From: Bloomer, David <David.Bloomer@lancashire.gov.uk>
Sent: 21 September 2015 14:50
To: Adrian Dowd
Cc: LHS Customer Service; planning; Stevens, Neil
Subject: app3/2015/0734 New Hall Barn, Ribchester Road

Dave Bloomer
Highways Development Control
Lancashire County Council

site plan
scale 1:250

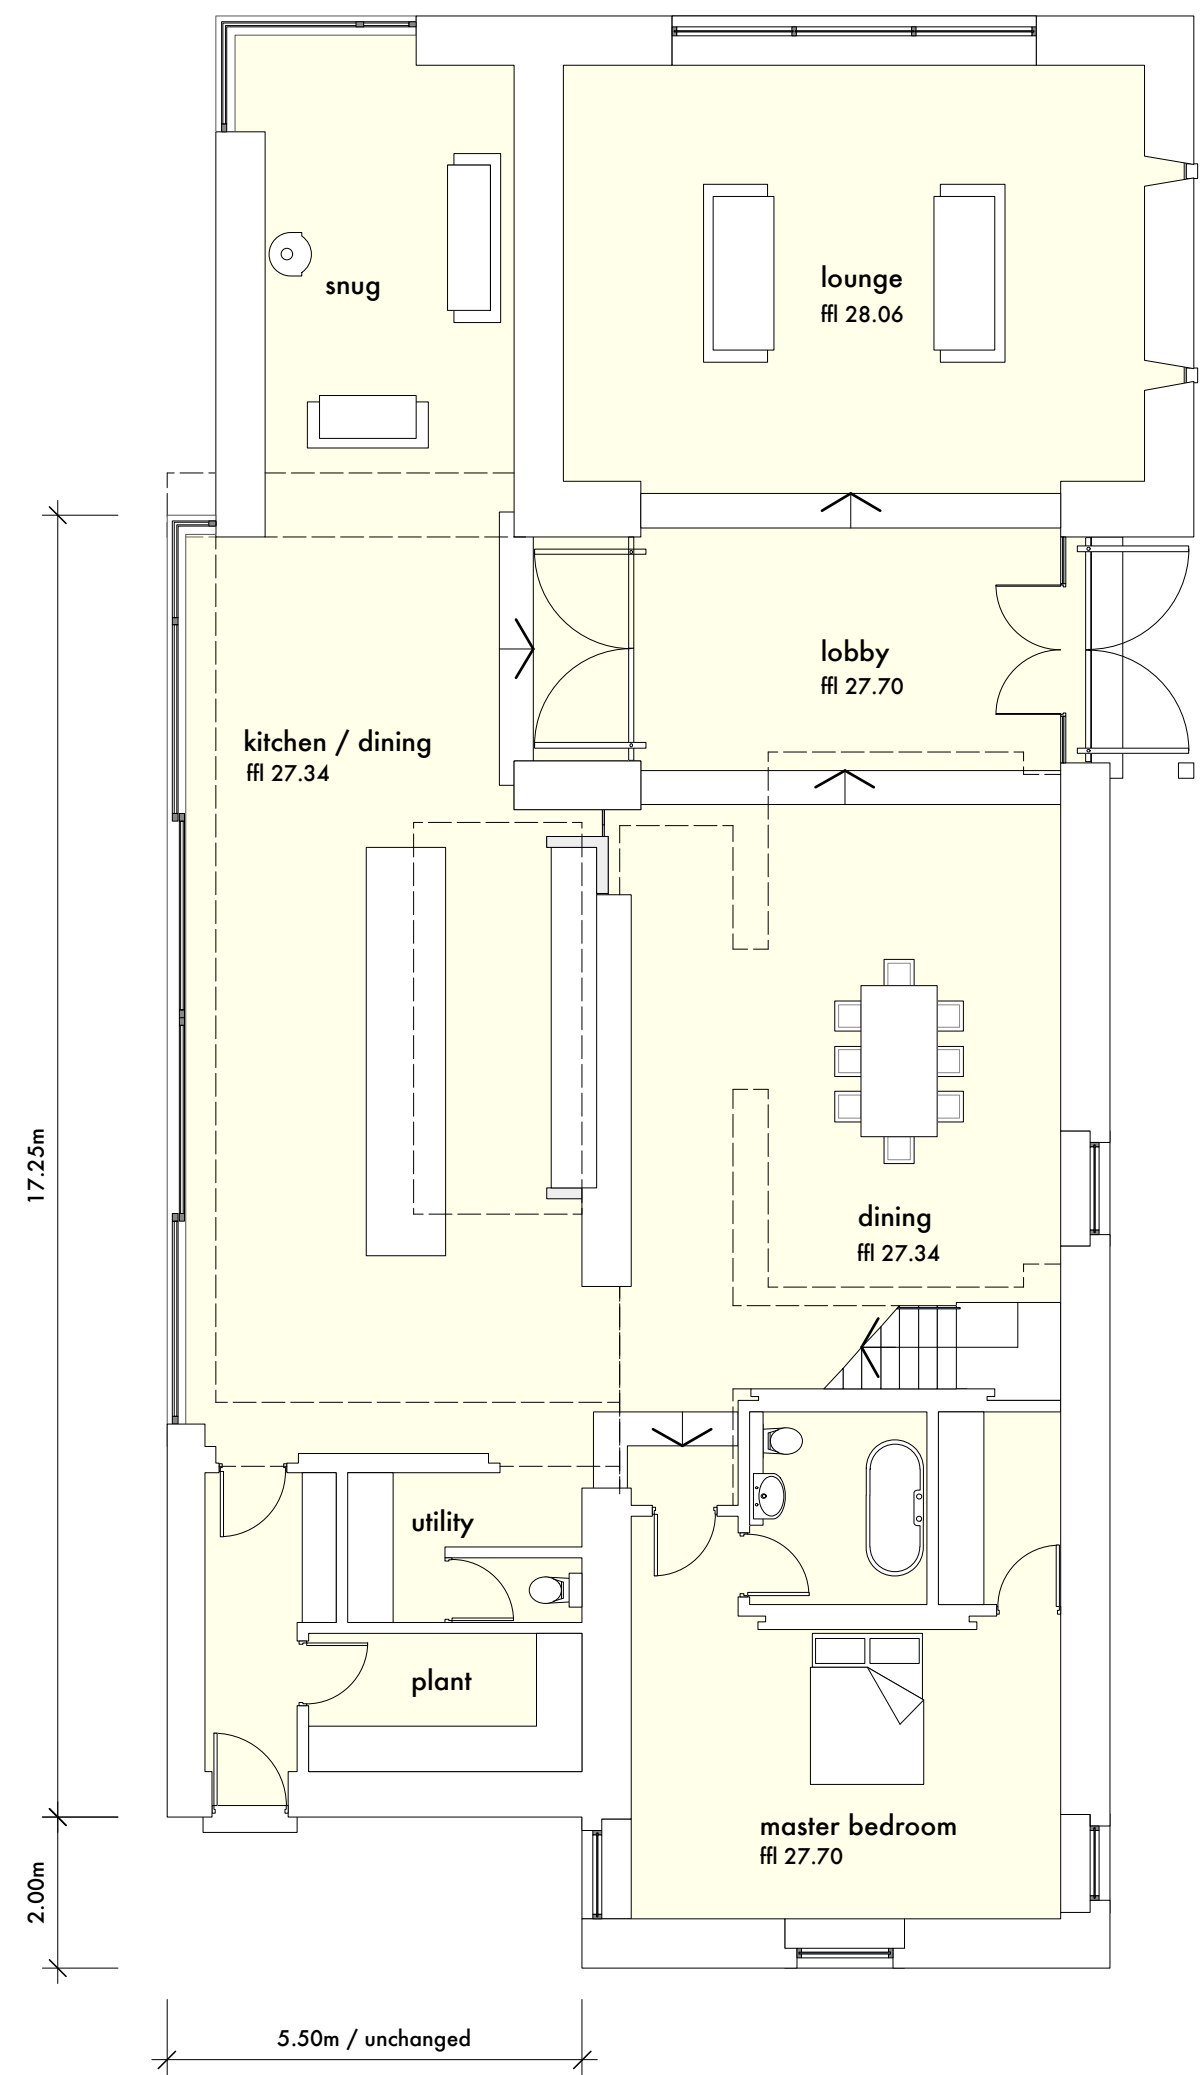
This application was subject to a pre app (March 2015) to which I raised no objection to the proposal in principle and this would still be the case, however from the layout plan submitted the new internal wall shown on the landscape layout unnecessarily restricts the parking / manoeuvring space within the courtyard parking area and I would suggest that its position should be reconsidered.
